# Planning Services Sign Permit Review Form

Date of Submittal	Application Number	Applicant	Landowner
6/09/2022	SIGN2206-0001	Southern Living Investment Properties	Southern Living Investment Properties

Contact Person	None listed on application	Contact Number	919-730-7802
Sign Location	Sign Easement lot 16 future Lane Farms Subdivision at the intersection of Wade Stephenson and Truelove Roads.	PIN Number	0635-07-4357.000

**Planning Services**  
**Sign Permit Review Form**  
**Location of Sign within Easement**

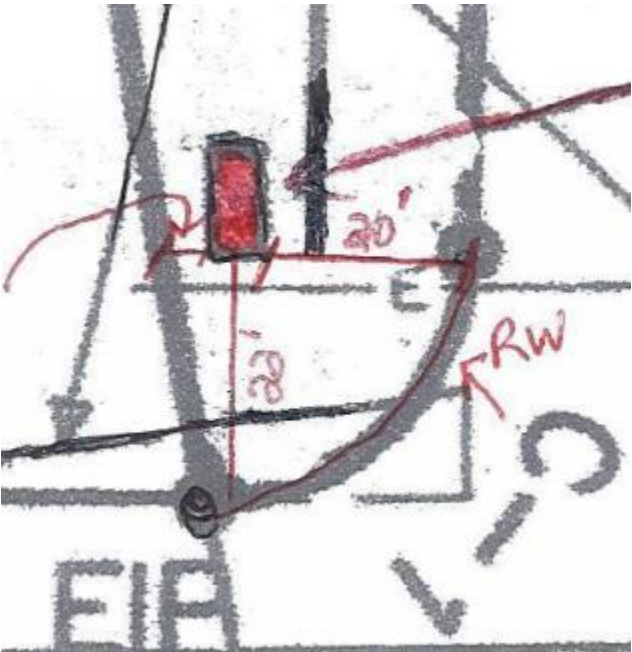
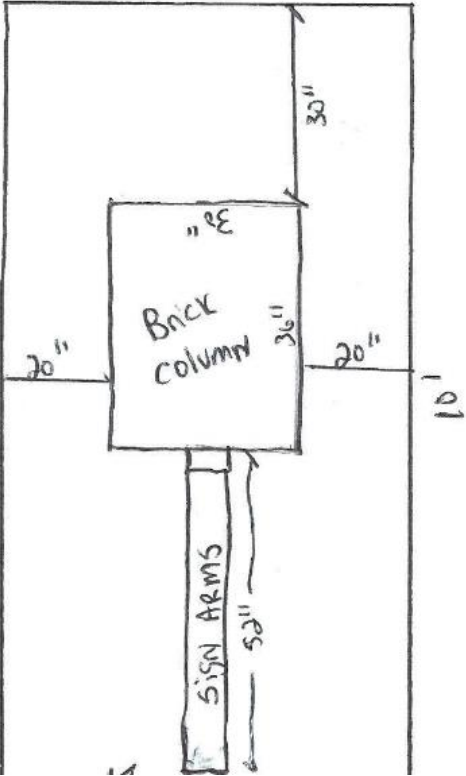
Comments	<b>More information is required. Please provide the distance between the sign and each ROW. 20' is required for signs located at an intersection.</b>
----------	---
